CITY OF ALBUQUERQUE

**Re: Guttman Residence, Lot 22 Rancho Guadalupe Subdivision
1626 Rancho Guadalupe Trail
Grading and Drainage Plan
Engineer's Stamp Date 08/23/2013 (F13/D002B)**

Based upon the information provided in your submittal received 10/28/2013, the following comments have to be addressed prior to an approval for Building Permit:

GRADING AND DRAINAGE PLAN

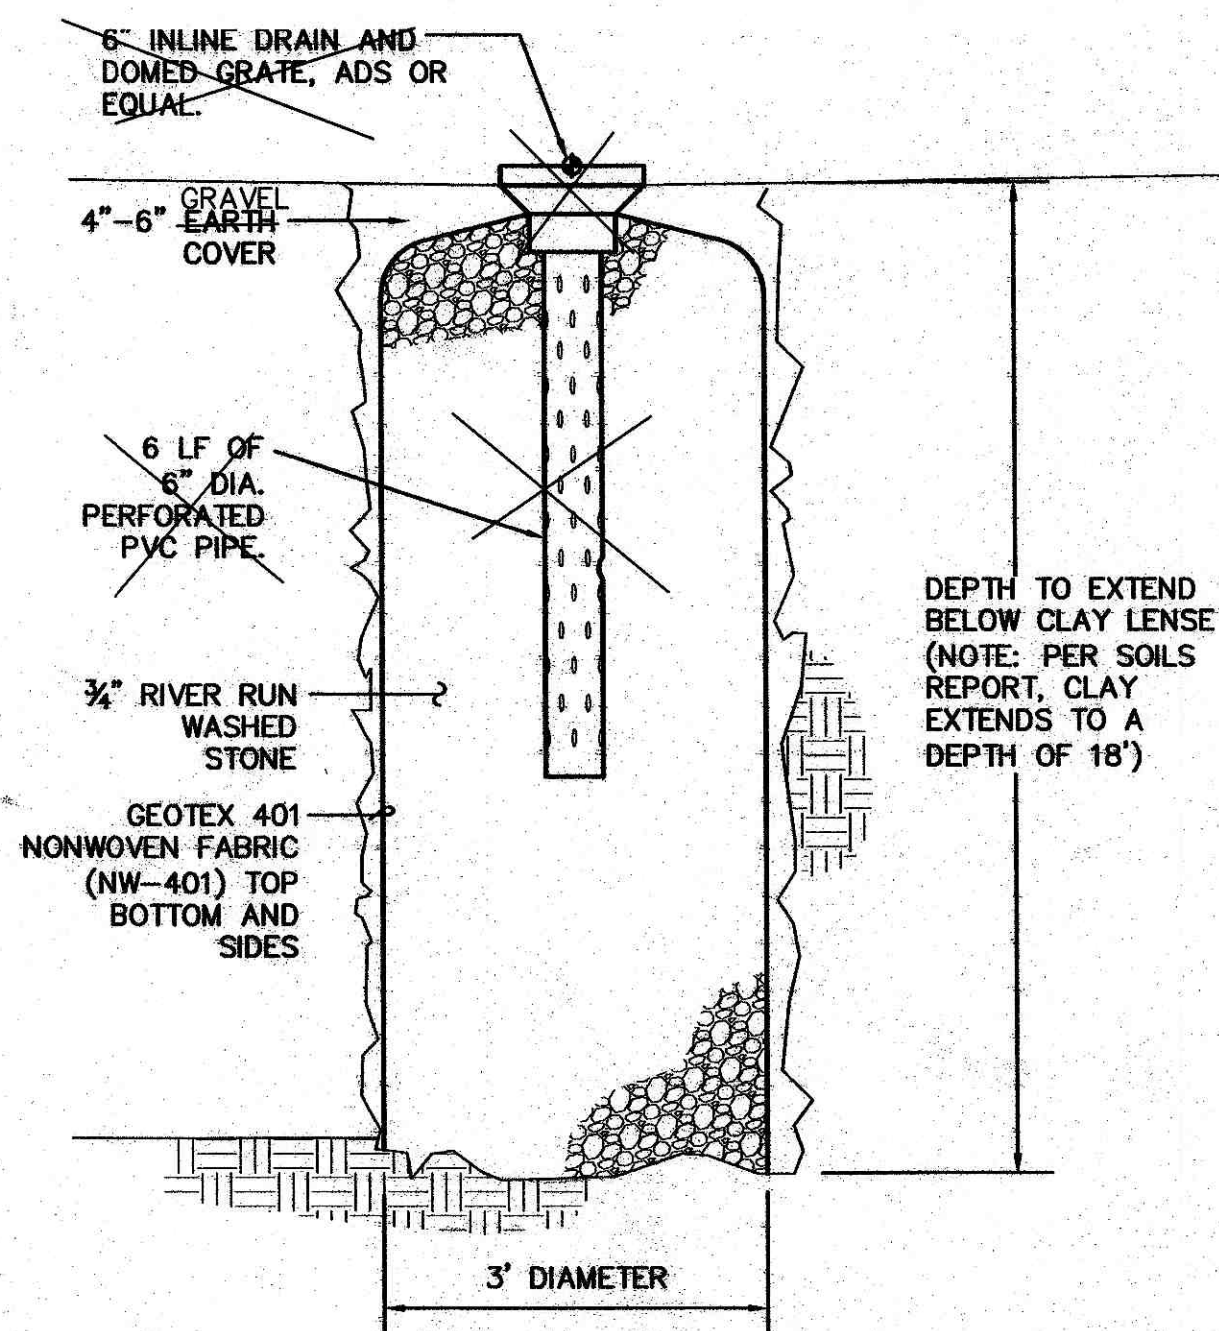
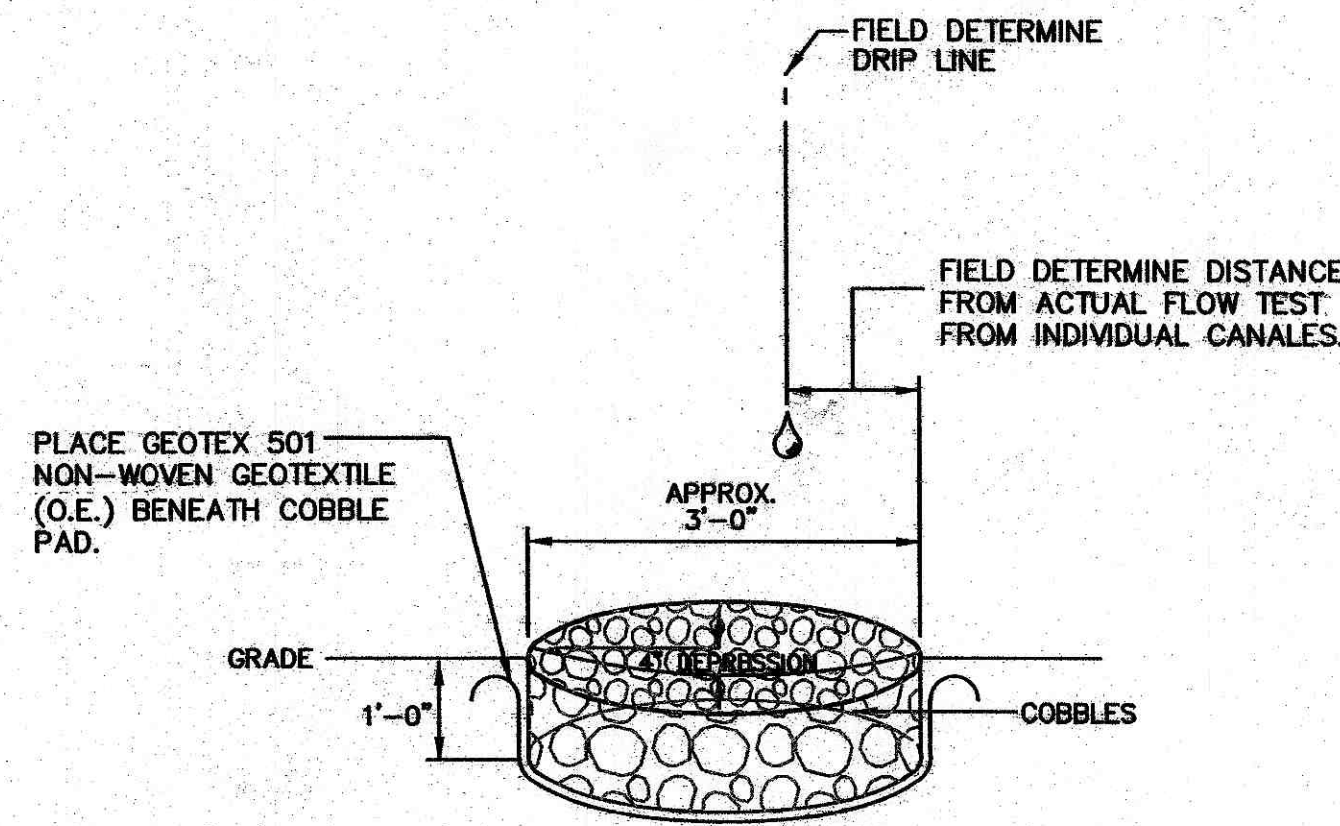
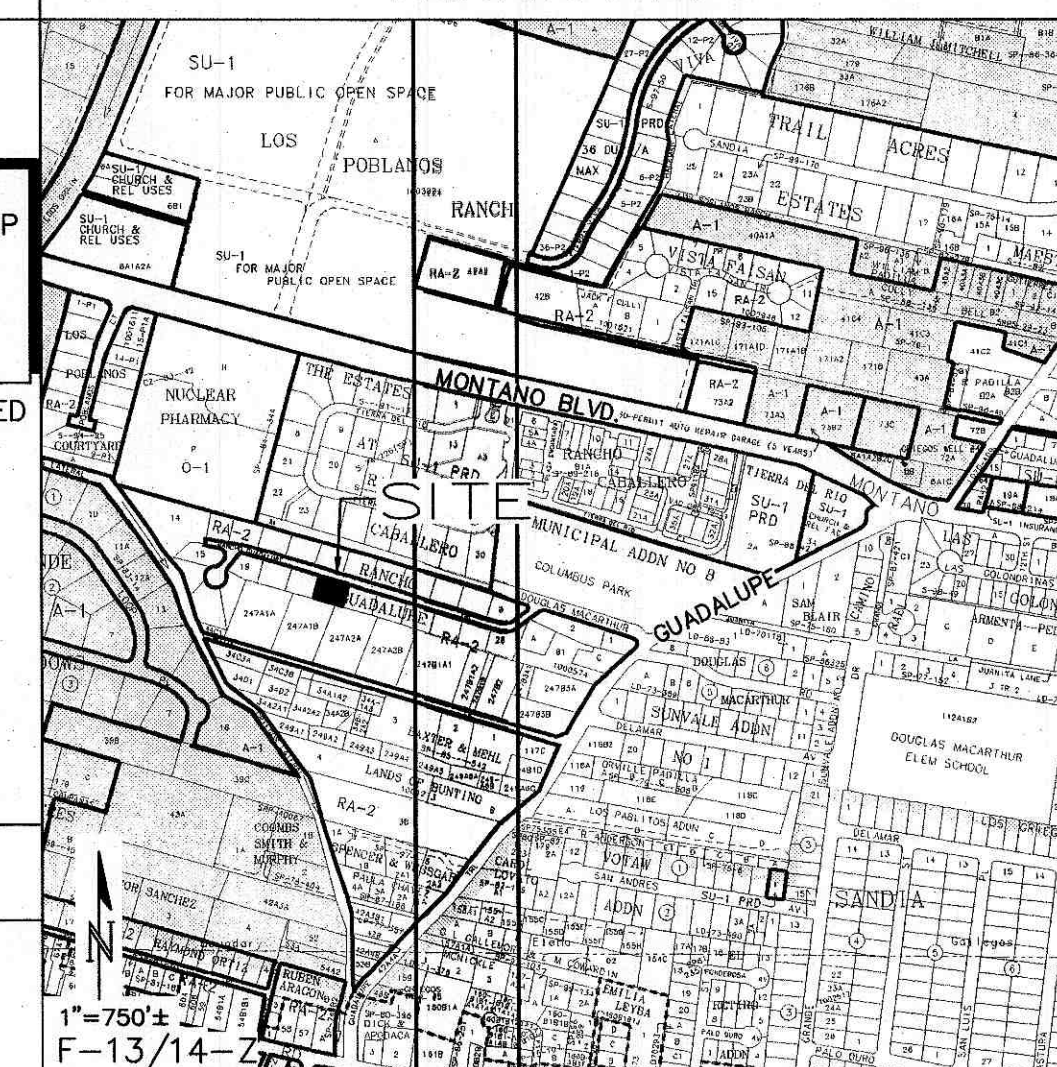
- Neither existing topography nor existing spot elevations are shown on the plan.
- A City of Albuquerque Benchmark with NAVD 88 elevation is shown on the plan, but the proposed elevations are the same as the original grading plan which an old Benchmark elevation.

- Provide pond volume calculations for the proposed ponds.
- Provide proposed and existing elevation at the south end of the property. What kind of slope is being proposed for the slope grade transition area?

- Provide additional spot elevations around the pool area to assure positive drainage.
- Clearly show the property line, and label all the existing easements on site. Is there a wall being extended to the northerly property line across the existing drainage easement?

SECTION 'A'

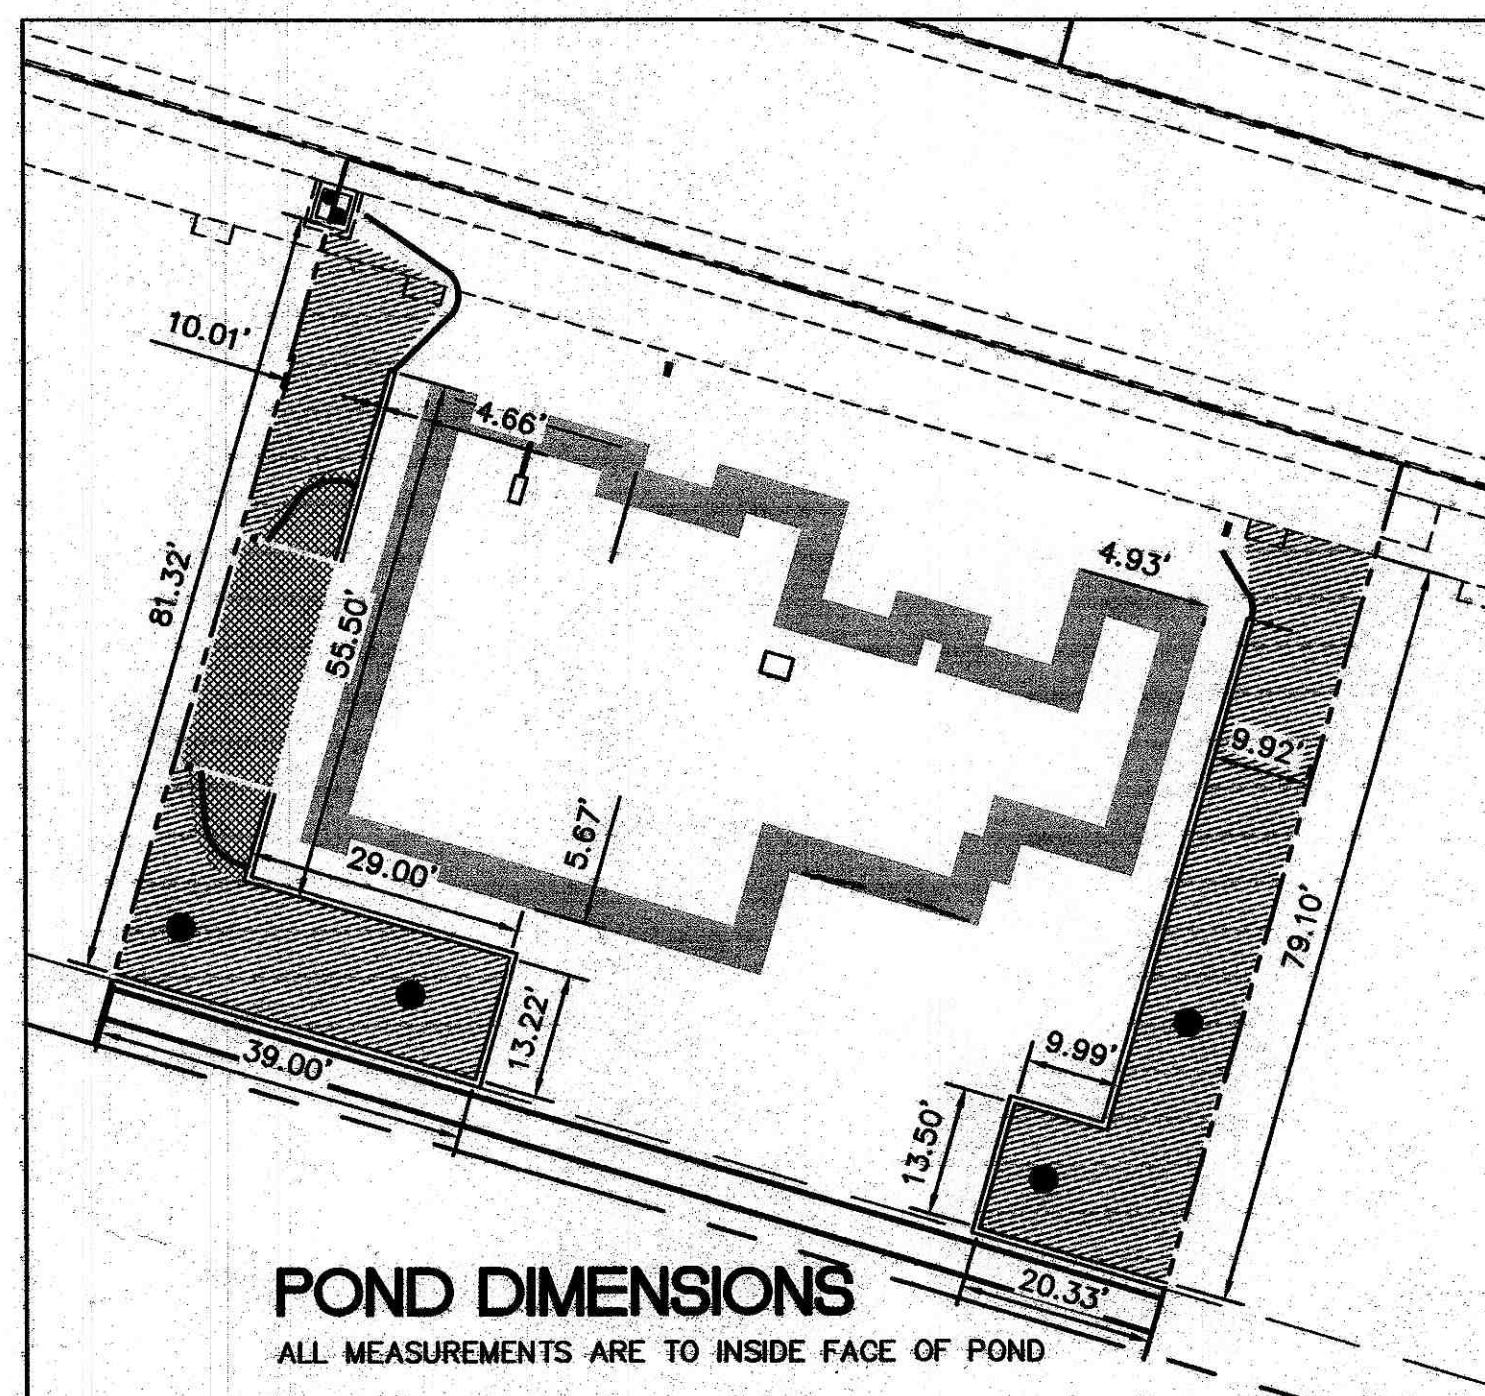
- Based on the overall grading and drainage plan, the low points between the pads are at the property lines to the east and to the west. Are these areas considered to be common drainage areas/easements? Will the proposed pond walls shown on Section A stop the runoff from the adjacent properties?
